Mining & Petroleum Gateway Panel

Report by the Mining & Petroleum Gateway Panel to accompany a Conditional Gateway Certificate for the West Muswellbrook Project

May 2015

**Figure 3: Geographical location of land designated by the NSW Government as potentially BSAL using the 1991 survey**

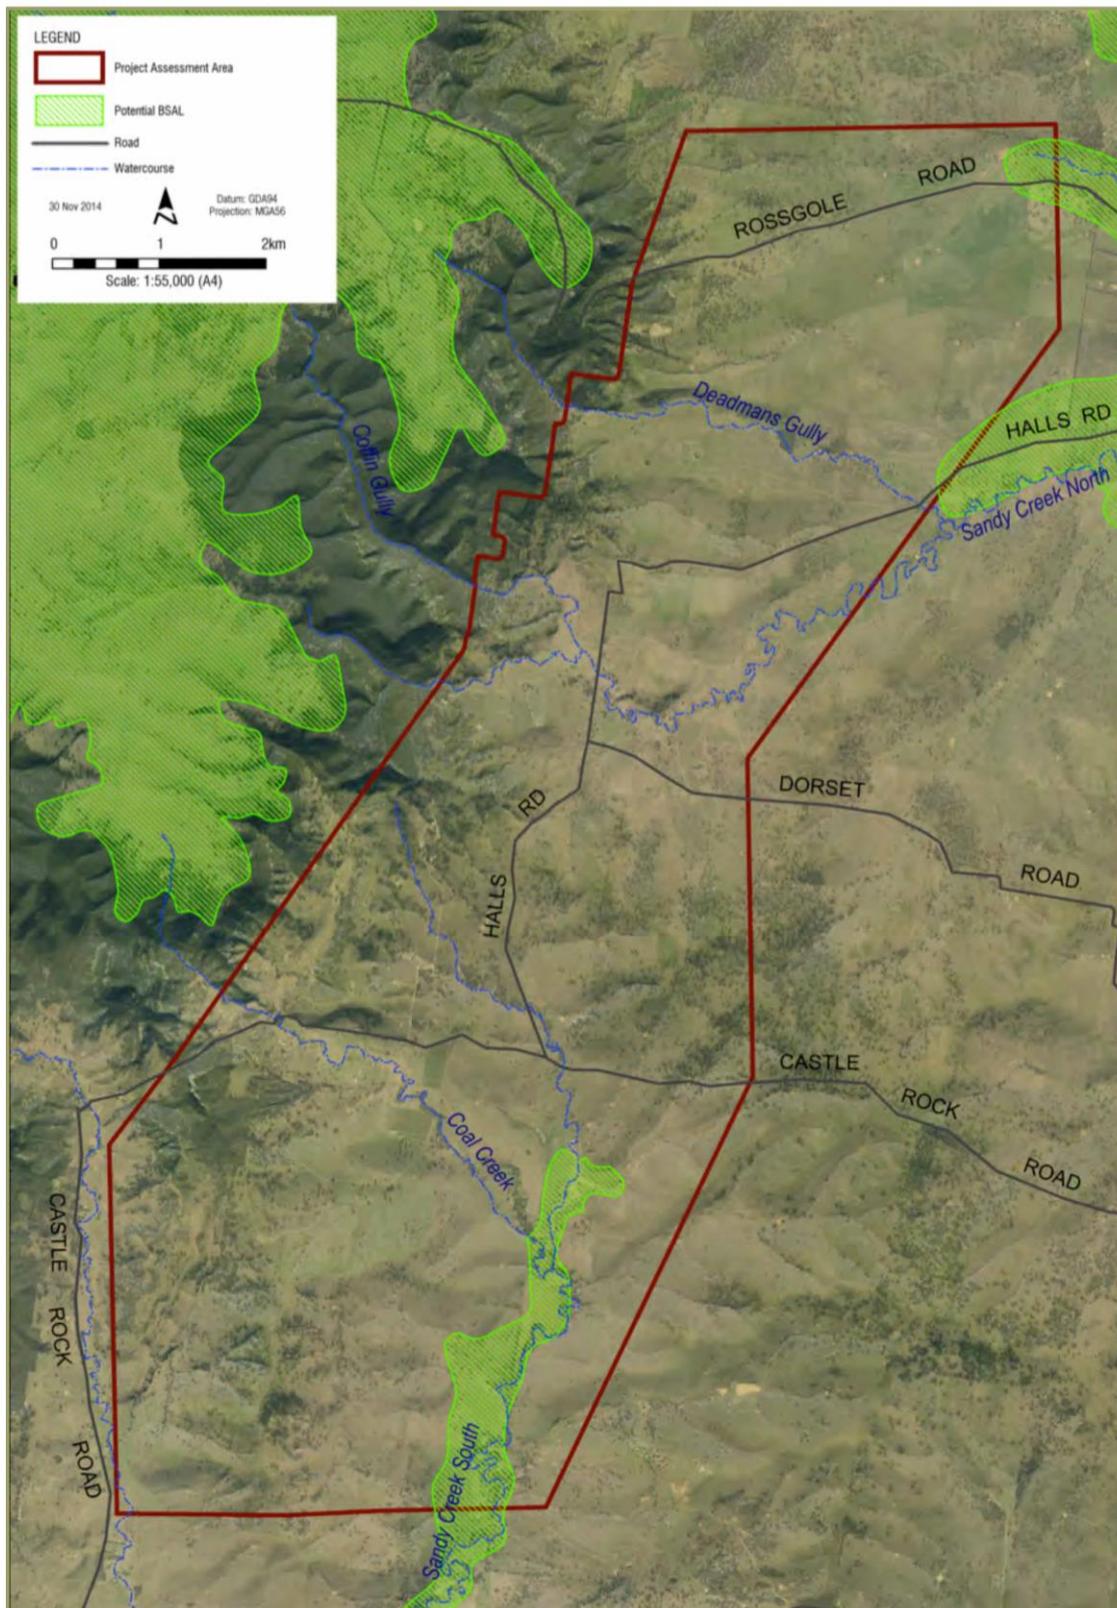
The PAA area has 206 ha of land designated and mapped by the NSW government as potential Biophysical Strategic Agricultural Land (BSAL) (Figure 3). Much of this potential BSAL lies within the proposed mine disturbance area. The Proponent has determined that much of this government mapped BSAL does not meet all the designated BSAL criteria and has proposed that this land is not BSAL. The Gateway Panel requests that the criteria used to exclude the following potential BSAL land be reviewed in terms of the following:

- The less than 20 ha extent criteria used to exclude site M34 is located on the South Eastern periphery of the PAA should be reviewed to determine whether there is contiguous BSAL land directly outside the PAA that might lead to the >20 ha criteria being satisfied.
- The chemical analysis used to determine that sites M2, M32 and M32 are not BSAL have been correctly adjusted for bulk density and saturation in the calculation of the salinity and chemical toxicity of these soils.

**Figure 4a: BSAL verified by the Proponent through on ground soil survey and analysis in the Northern section of the PAA.**

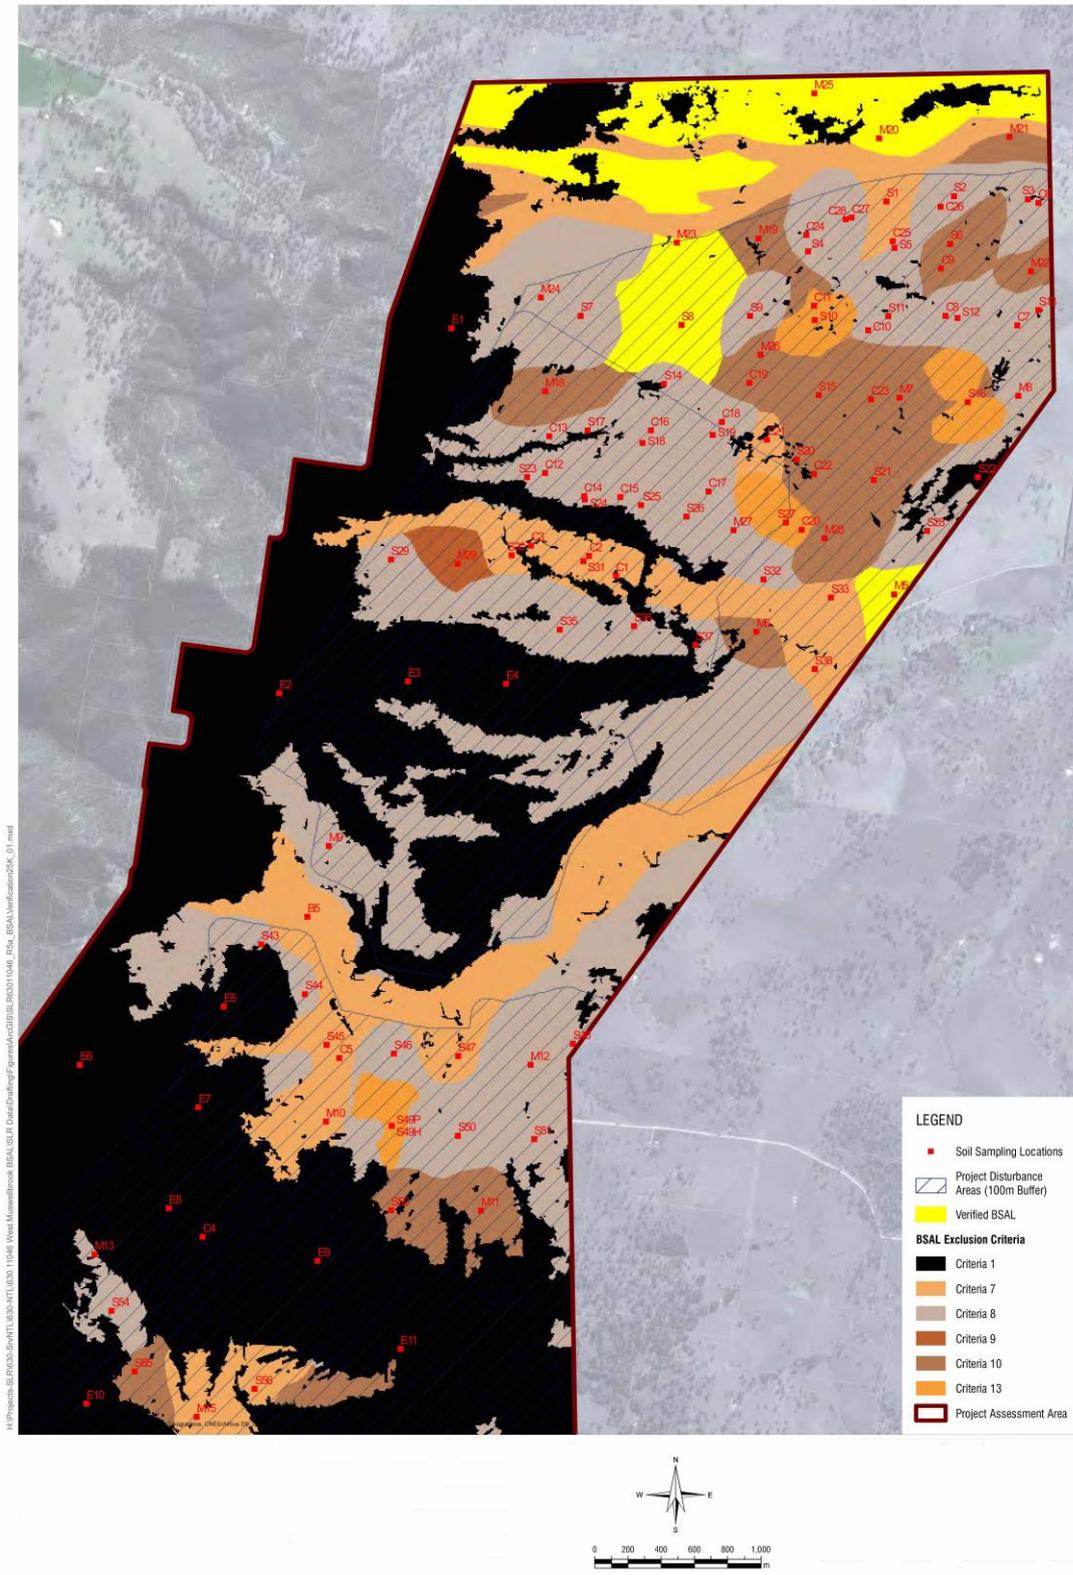
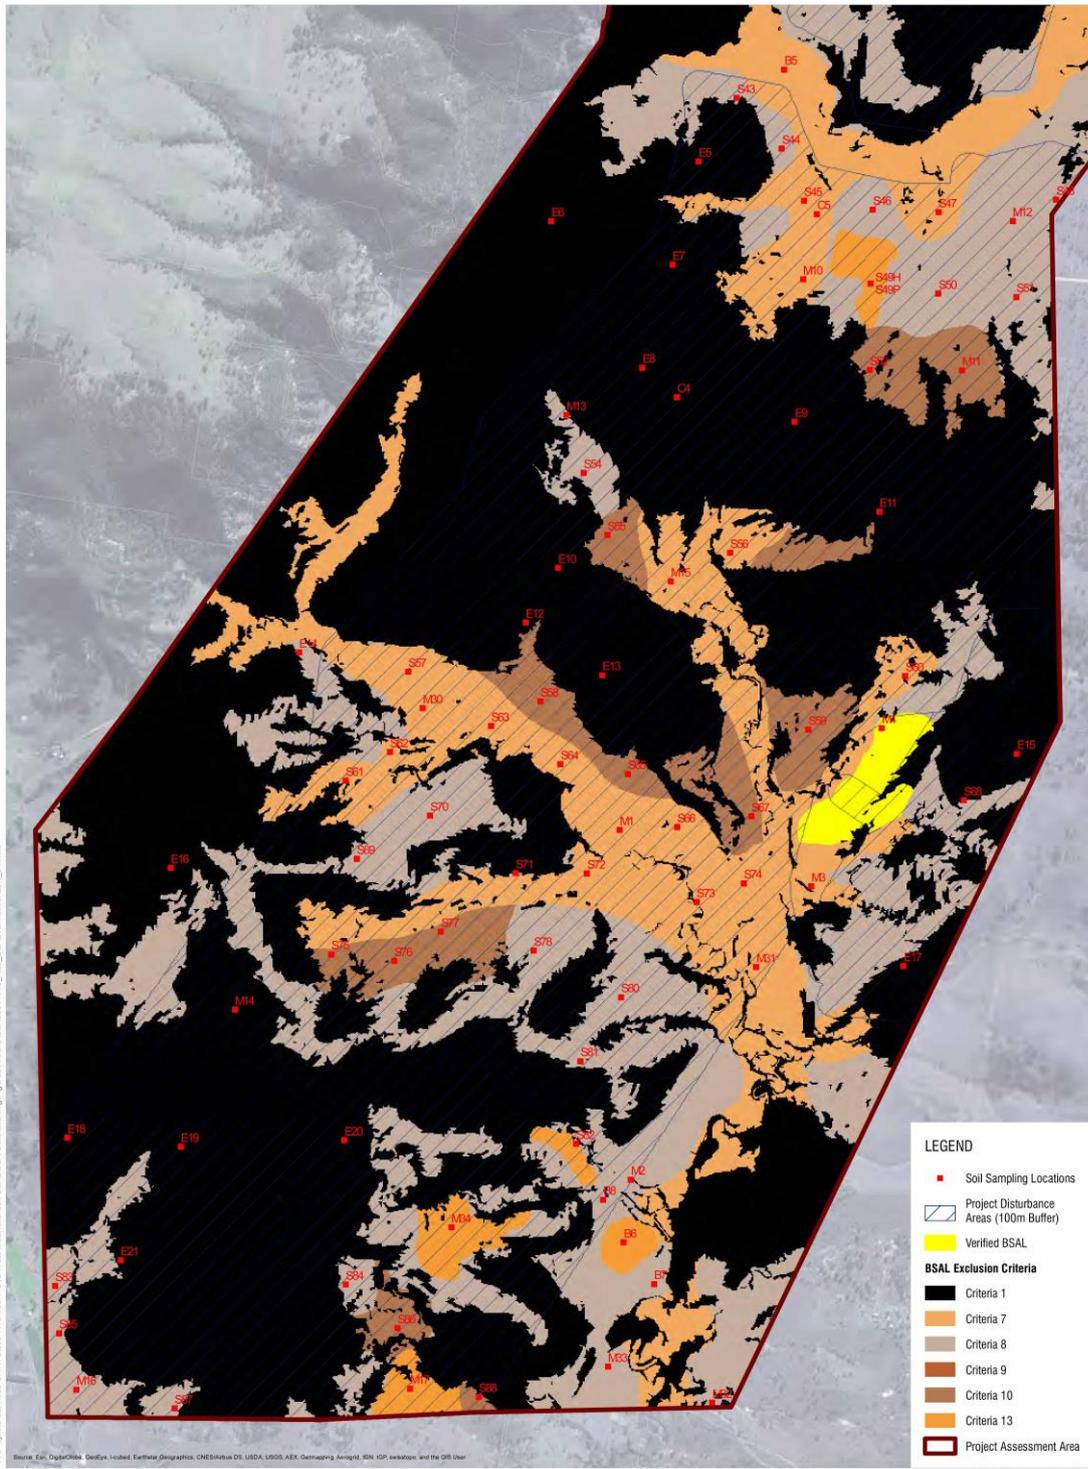
The Proponent through a soil survey and chemical analysis methodology has identified that the PAA contains 204.6 ha of verified BSAL (Figure 4a & Figure b) Much of this verified (136.2ha) BSAL lies in the Northern part of the Project area adjacent to Rossgole Road and is outside of the disturbance area (Figure 4a). The majority of the verified BSAL is located on Land and Soil Capability Class 2 and 3 indicating that it is capable of a wide variety of land uses (cropping, grazing, horticulture, forestry, nature conservation).
